From: Mark Jones
Sent: 04 September 2017 10:22
To: Planning
Subject: FW: M/56/17/HH 8 Beaconsfield Close Middleton-On-Sea PO22 7SH

M/56/17/HH 8 Beaconsfield Close Middleton-On-Sea PO22 7SH

Further to your request please find attached drawings with Revision A marked to avoid confusion.

Date	Drawn	Scale	Checked
May 2017	wm	1 : 100 @ A3	
Job Number	Prefix	Drawing Number	Revision
1721	P	05

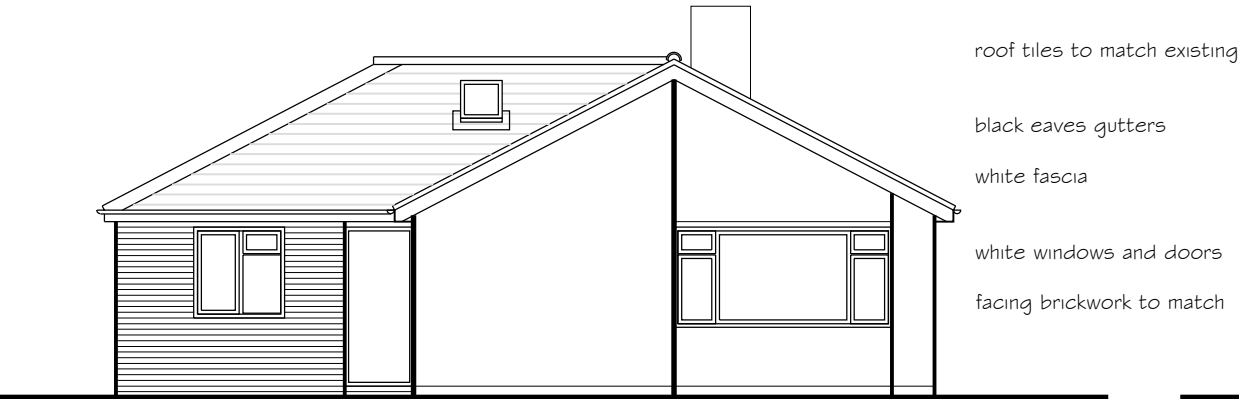
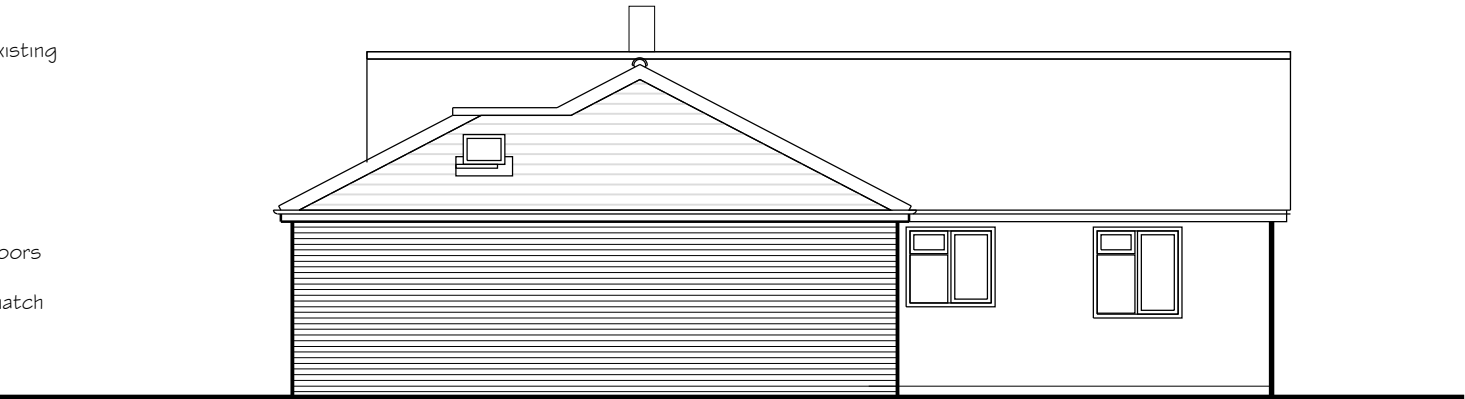
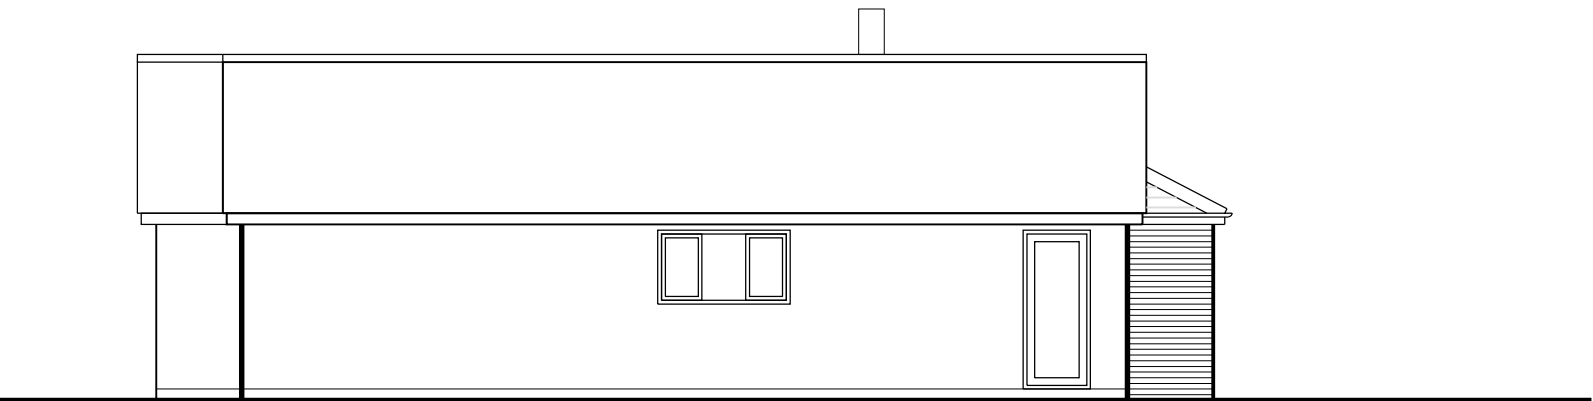
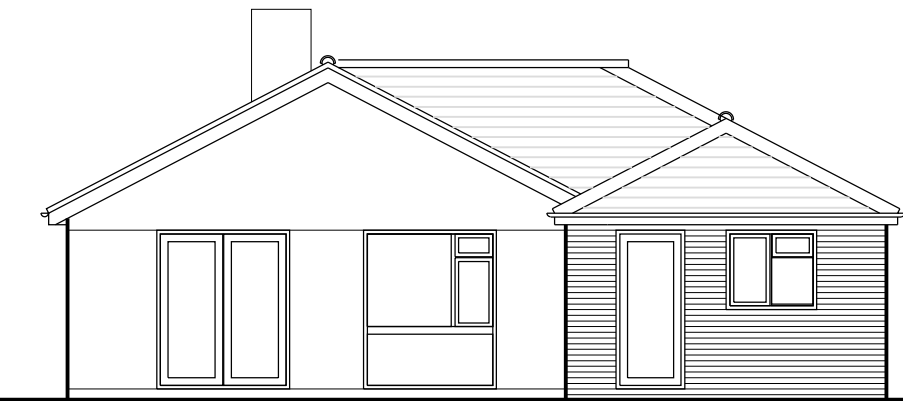
Thanks for the mail apologies I was away on Friday. I have written up the application with a positive recommendation over the weekend. However, I noticed one minor issue when drafting the conditions. I notice the amend plans 1721 P 01, 04 and 05 have the same dwg number as the original to avoid confusion could these be changed to show Rev A? if you can forward the amended plans to me by e mail I will submit my report to managers straight away.
